Planning Application Ref: AW/171/17/T

Location: 9 Ripon Gardens, Aldwick

Description of works: Fell 1 No Oak & 1 No Sycamore & 1 no Conifer hedge

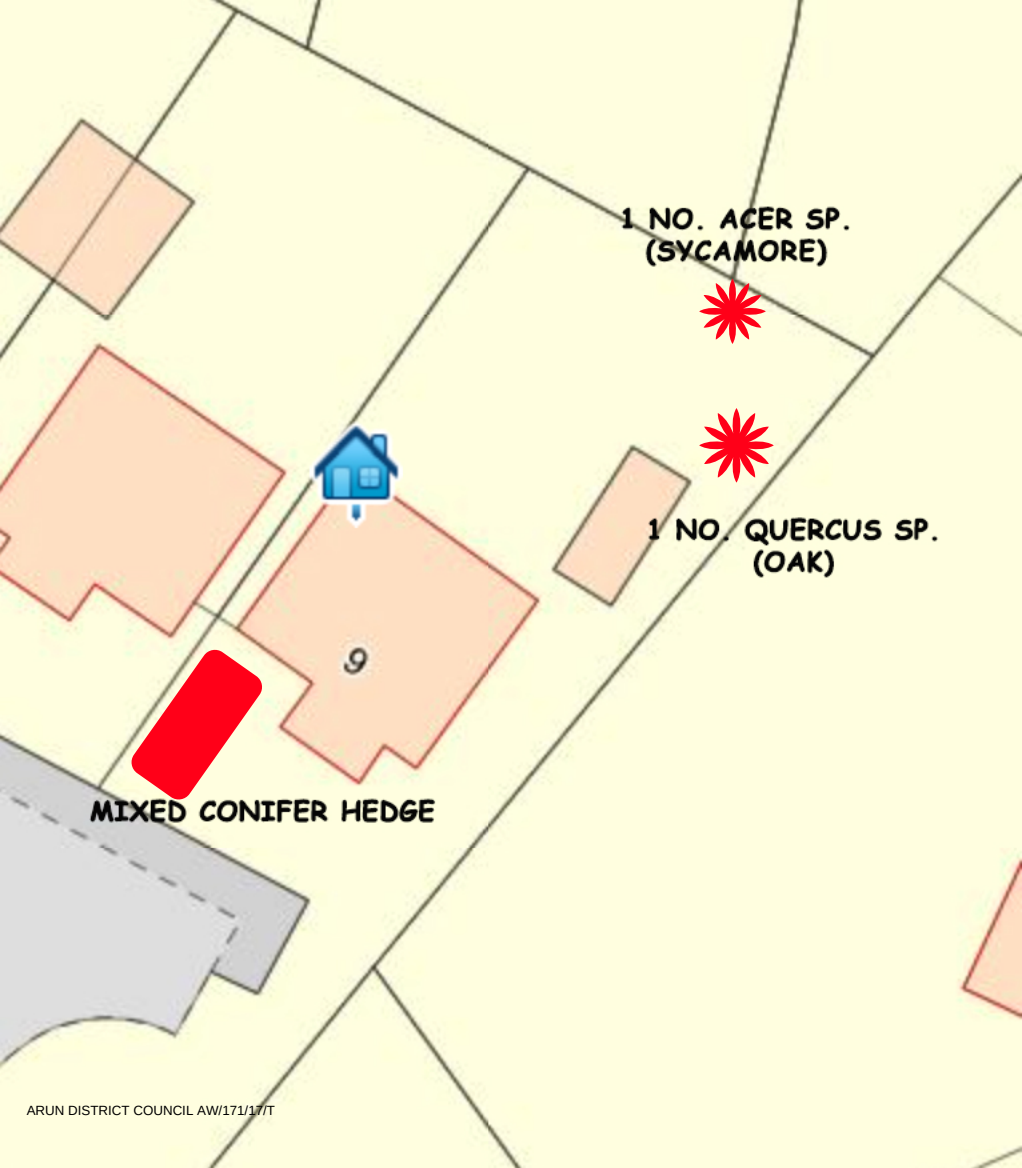
- The Sycamore and the Conifer hedge are sound and healthy but the Oak is suppressed with low crown density and dieback and a basal cavity.

- The Oak is undermined by decay and showing the results of this in its low density crown.
- The Sycamore has minor damage on its trunk due to a constricting washing line (now removed) but this is not a significant issue – however it will in time grow into a very large tree at this location and cause problems with light restriction and ‘aphid drip’ in a small back garden.
- The Golden conifers are only young and in time if not regularly lopped and topped will dominate the front garden and cause significant light restriction problems.

- I recommend **APPROVAL** of all of the works as described in the application – namely the removal of the two trees and the hedge.
- There will be a requirement to replace the Sycamore close to the same location with a standard sized Field Maple.
- There will not be a requirement to replace the Oak because off site tree will dominate it and there is no chance of a successful establishment.
- There will be a requirement to replace the conifer hedge with either feathered Beech or Hornbeams to form a new hedge.

- Once the Sycamore tree has been removed in a safe and controlled manner and the stump and primary root runs ground or grubbed out a replacement tree is to be planted nearby.
- This is to be of Standard Nursery Stock size – a tree of 8ft to 10ft in height and 8cm to 10cm in circumference staked and tied on a short staking system planted within 12 months of the original trees removal.
- It is to be of the following species:-

Field Maple – *Acer campestre*
